June 8, 2022

Subject: **Response to Geotechnical Peer Review Comments Regarding  
2204-107-SUB1-PLANS**

Proposed Mercer Island Treehouse Residence  
5637 East Mercer Way  
Mercer Island, Washington

1 PILE SECTION @ HOUSE (MAIN HOUSE)

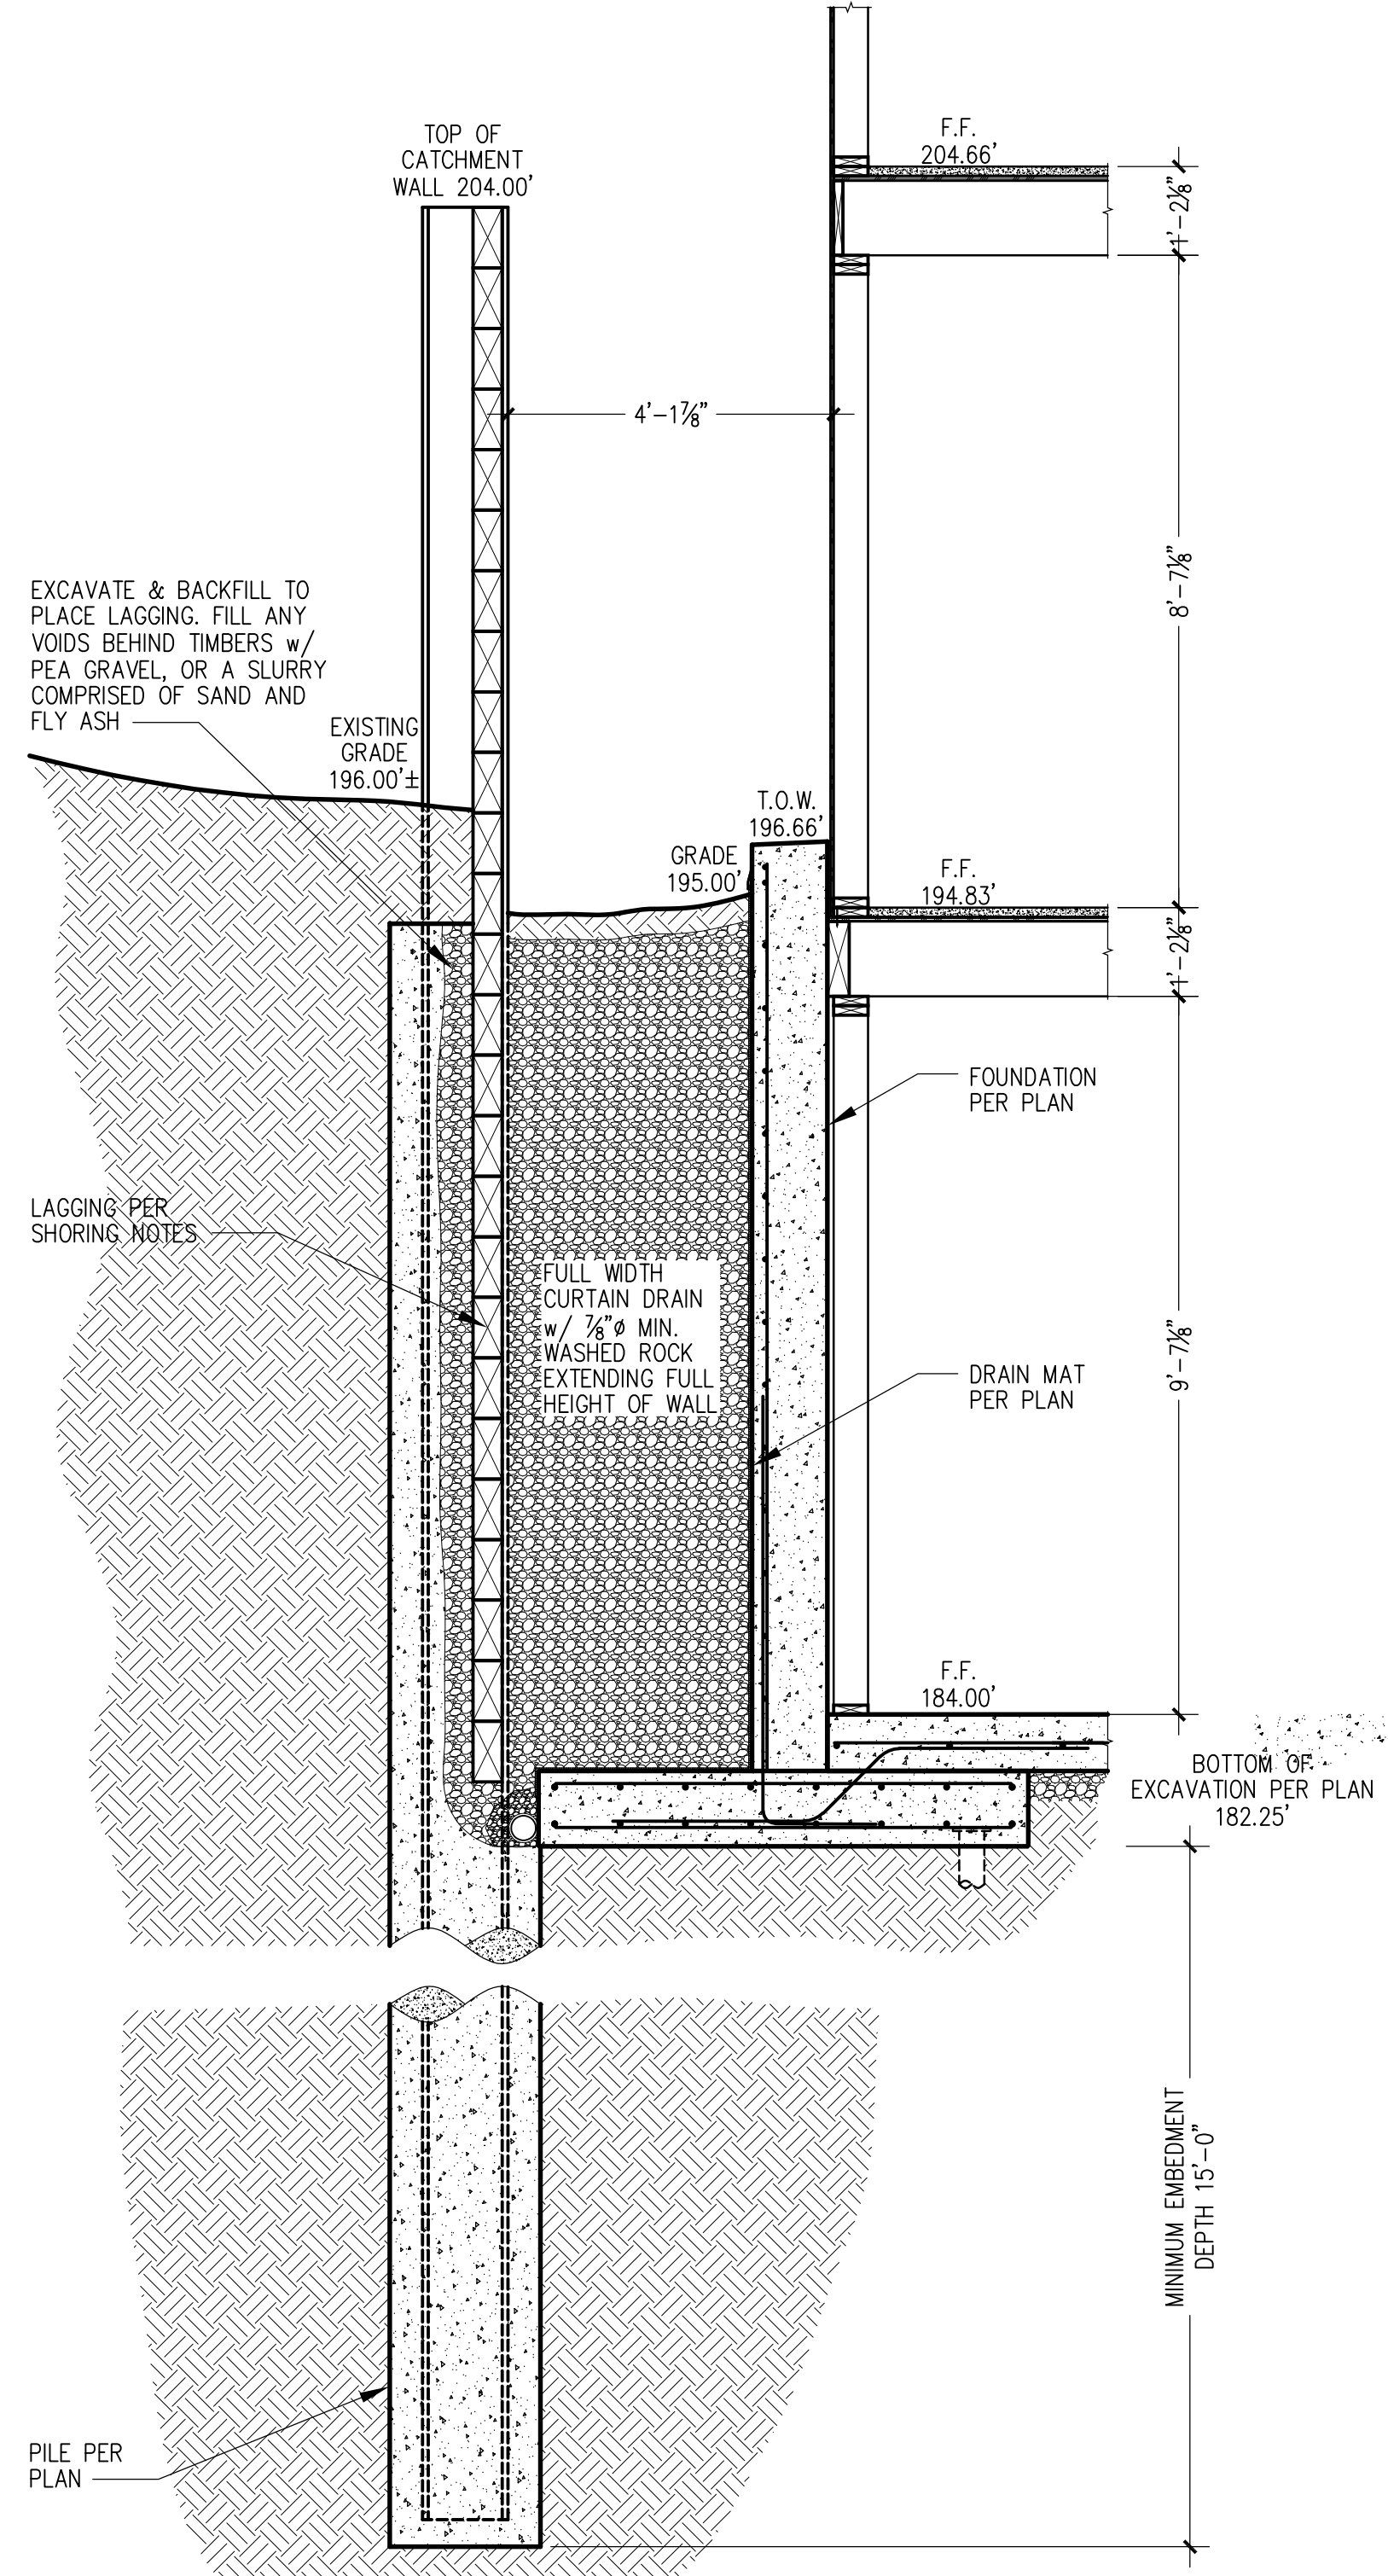
**Number: 1** *Isn't this retaining a fill? Wouldn't it be easier to provide drainage and piping behind the wall?*

*Provide details on how this wall will be drained or design facing for hydrostatic pressures.*

**Response:** This wall shown on detail 3/P1.1 will be a backfilled soldier pile wall extending along the north side of the driveway. This is also depicted on the North Elevation on sheet A3.4. The driveway area behind the wall will be covered with pavement, preventing infiltration of precipitation into the backfill zone. Groundwater will be below the backfill zone, within the native soils. As a result, the potential for any significant amounts of subsurface water behind the above-grade portion of the wall is low. Drainage of any minimal amounts of water that may accumulate in the backfill could be handled either by a footing drain installed below the existing grade behind the soldier piles, or by installing weep holes through the base of the concrete wall facing. Two-inch-diameter weep holes on 6-foot spacing would be appropriate. If the soldier pile wall is constructed without a concrete facing, the treated timber can be backfilled with clean gravel, and any small amounts of subsurface water will simply weep out through the lagging.

PILE PLAN

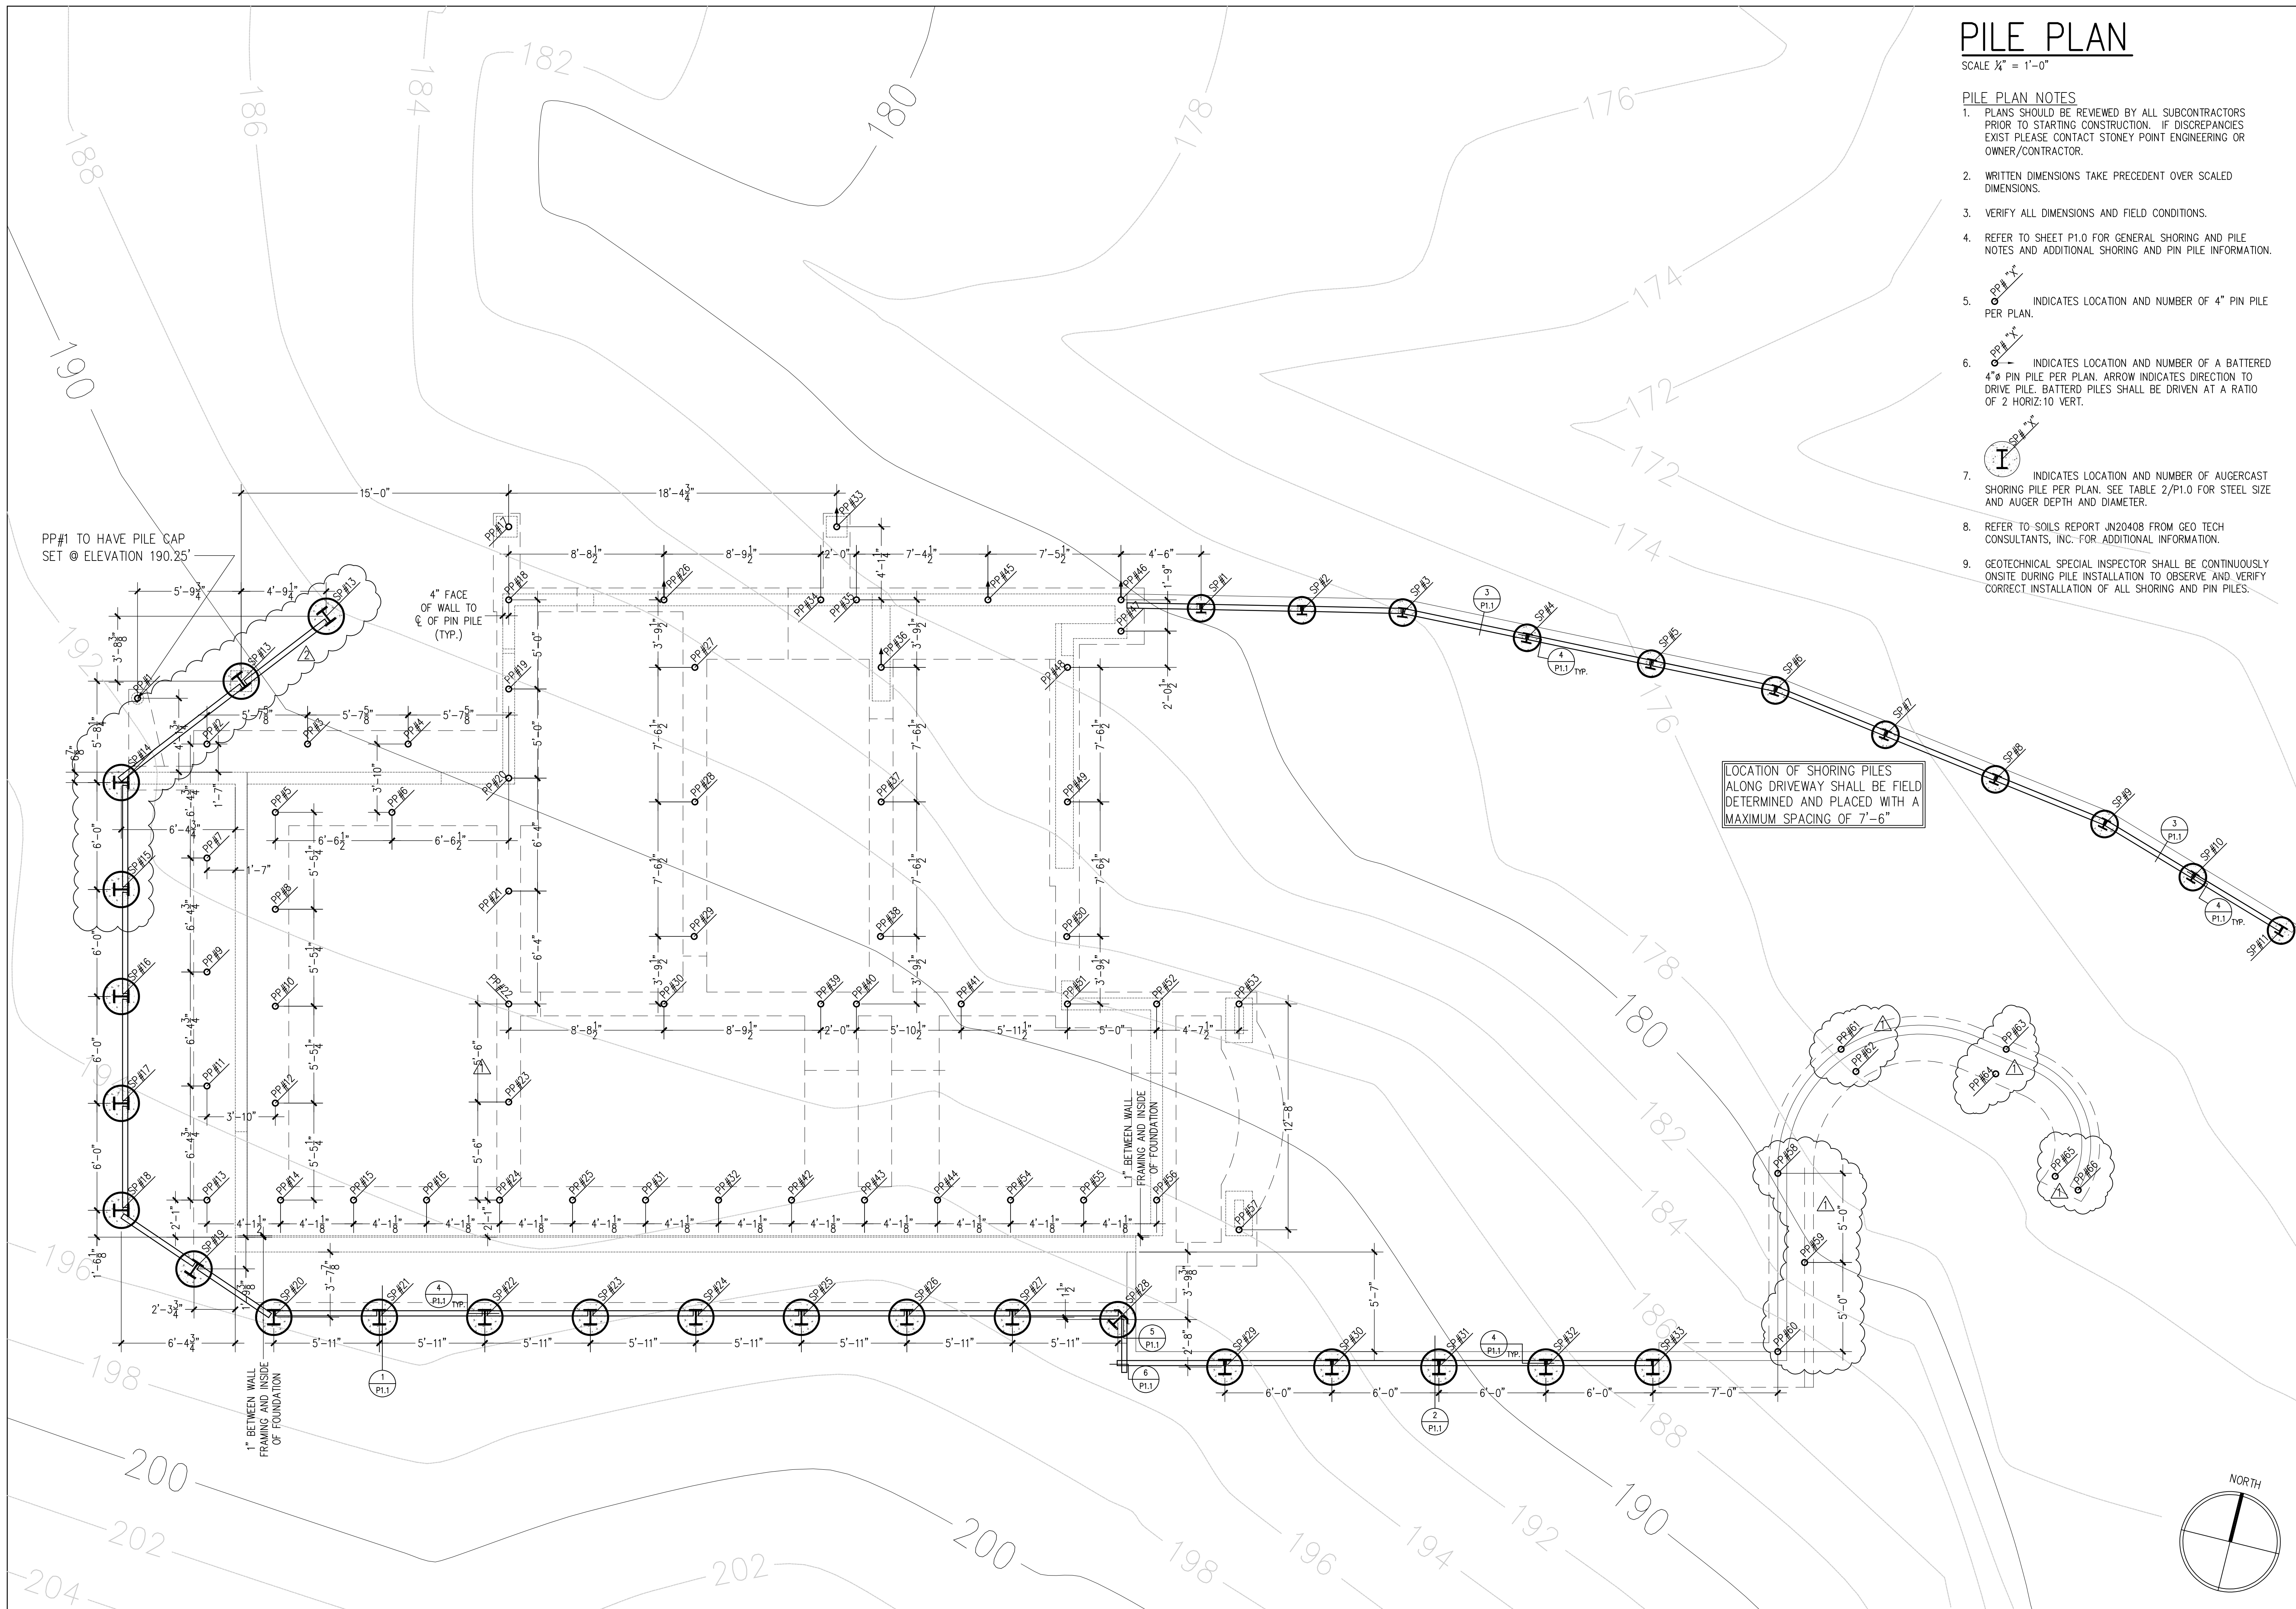
**Number: 1** *The wall located adjacent to sloping ground conditions should be designed with reduced passive pressures. Geotechnical engineer to provide recommended values to take into consideration these sloping ground conditions. This value should also take into account saturated soil conditions.*

*Revise structural design accordingly.*

**Number: 2** *Are you backfilling here as shown in Detail 1/P1.1? Are you providing a wall to return? Or permanent slope fill past the end of the shoring wall? Provide final grading if fill slope is proposed.*

*Revise plan sheet.*

**Response:** The slope in front of the northern driveway soldier pile retaining wall is located above a short slope only 5 feet in height. Rather than utilizing a reduced passive pressure on the embedded portion of the piles, we recommend that the piles be designed for an active earth pressure acting to 2.5 feet (one-half of slope height) below the existing grade. The passive pressure below this 2.5-foot depth should be an ultimate value (no safety factor included) of 225 pounds per cubic foot (pcf) acting on 2 times the drilled pile diameter. This passive value accounts for the buoyant unit weight of the soil below the water table.

**Response:** The retaining wall indicated in this comment is actually a landslide catchment wall consisting of soldier piles that extend above the ground surface. The base of the catchment wall will follow the existing grade, and will not retain fill above the existing grade.

There is no need to revise the plan sheet for this item.
